**Zoning Confirmation Report – 200 Isabella Street**
**A. Project Information**

<b>Review Date</b>	April 17, 2026	<b>Official Plan Designation</b>	Inner Urban Transect, Neighbourhood Designation, Evolving Neighbourhood Overlay
<b>Municipal Address</b>	200 Isabella Street	<b>Legal Description</b>	LOTS 11, 12, 13, 14, 15, 16 & 17 AND PART OF THE 10 FOOT LANE, SOUTH ISABELLA STREET, REGISTERED PLAN 34325, CITY OF OTTAWA
<b>Scope of Work</b>	Site Plan Control		
<b>Existing Zoning</b>	GM4 [2912] S486	<b>By-law Number</b>	2008-250
<b>Schedule 1/1A Area</b>	Area B	<b>Overlays Applicable</b>	N/A

SP-01

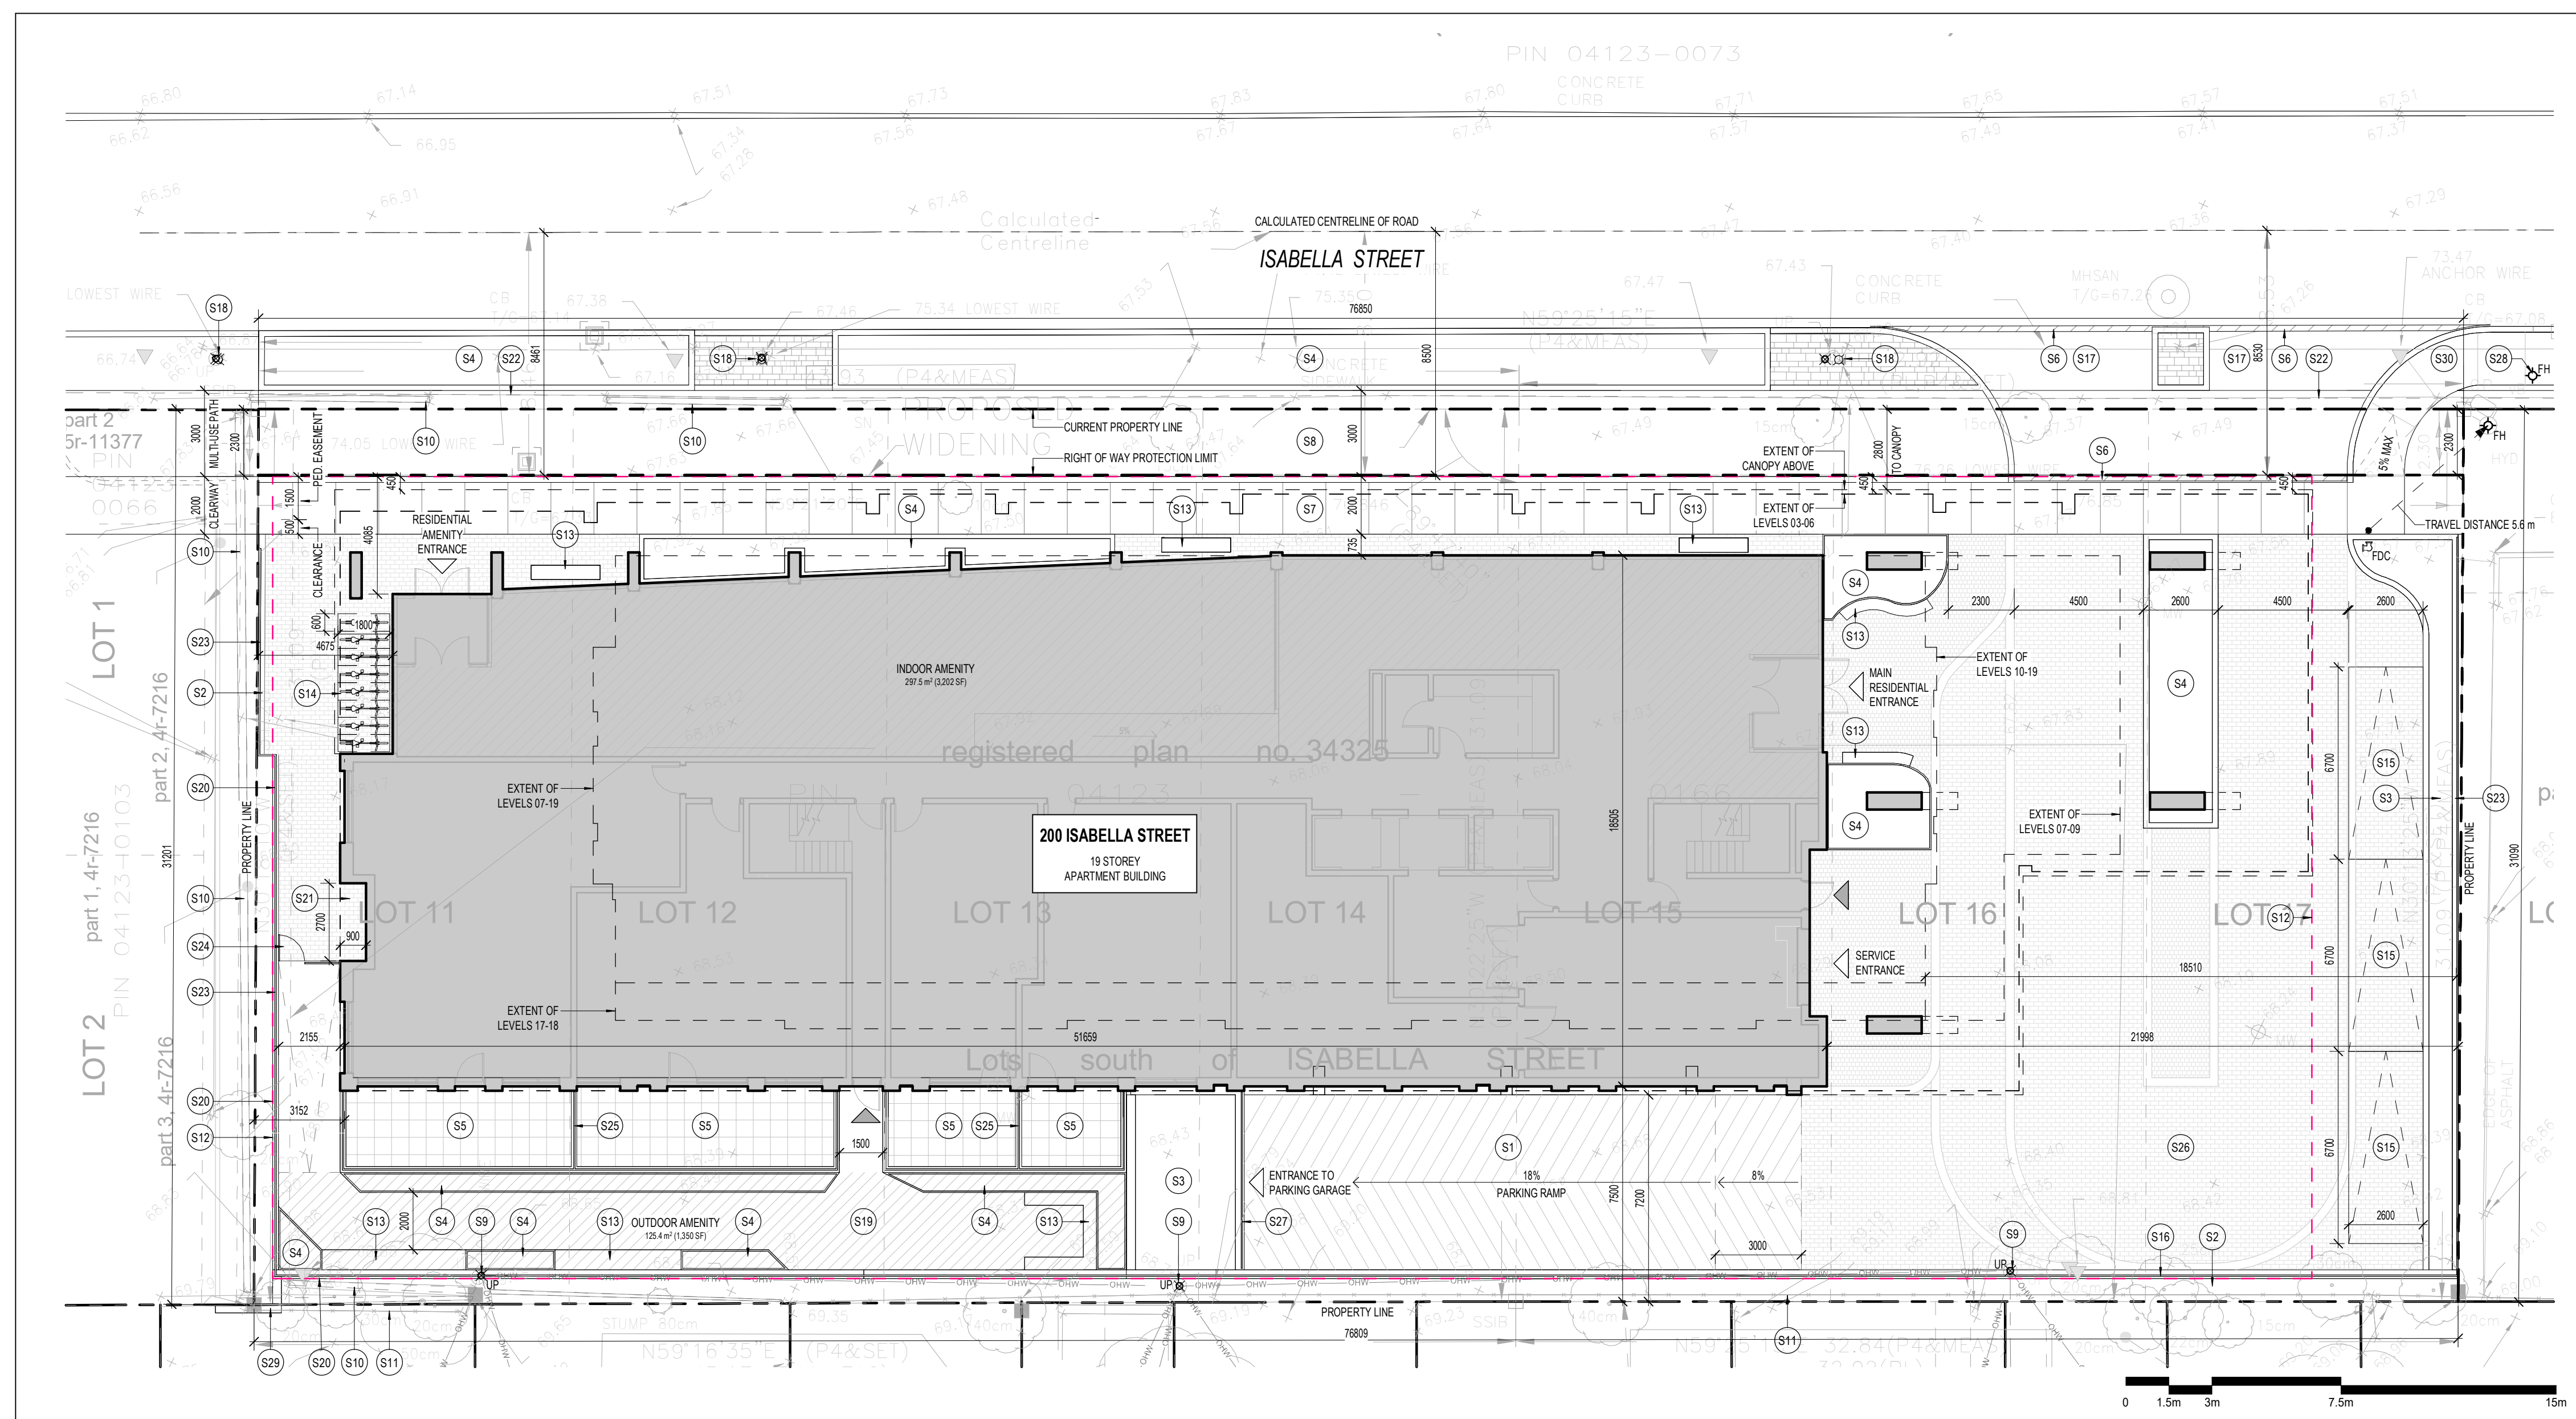
Maximum Building Height	60.0m	60.0m	<b>Y</b>
Minimum Width of Landscape Area	No minimum	1.5m	<b>Y</b>
Required Parking Spaces (Residents)	98 spaces 0 spaces for the first 12 units, 0.5 spaces/unit for 217 units, less 10% for underground parking	<b>77 spaces</b>	<b>N</b>
Required Parking Spaces (Visitor)	22 spaces 0 spaces for the first 12 units, 0.1 spaces/unit for 217 units	22 spaces	<b>Y</b>
Small Car Parking Spaces	39 spaces Up to 50% of spaces may be reduced to 4.3m by 2.4m	<b>40 spaces</b>	<b>N</b>
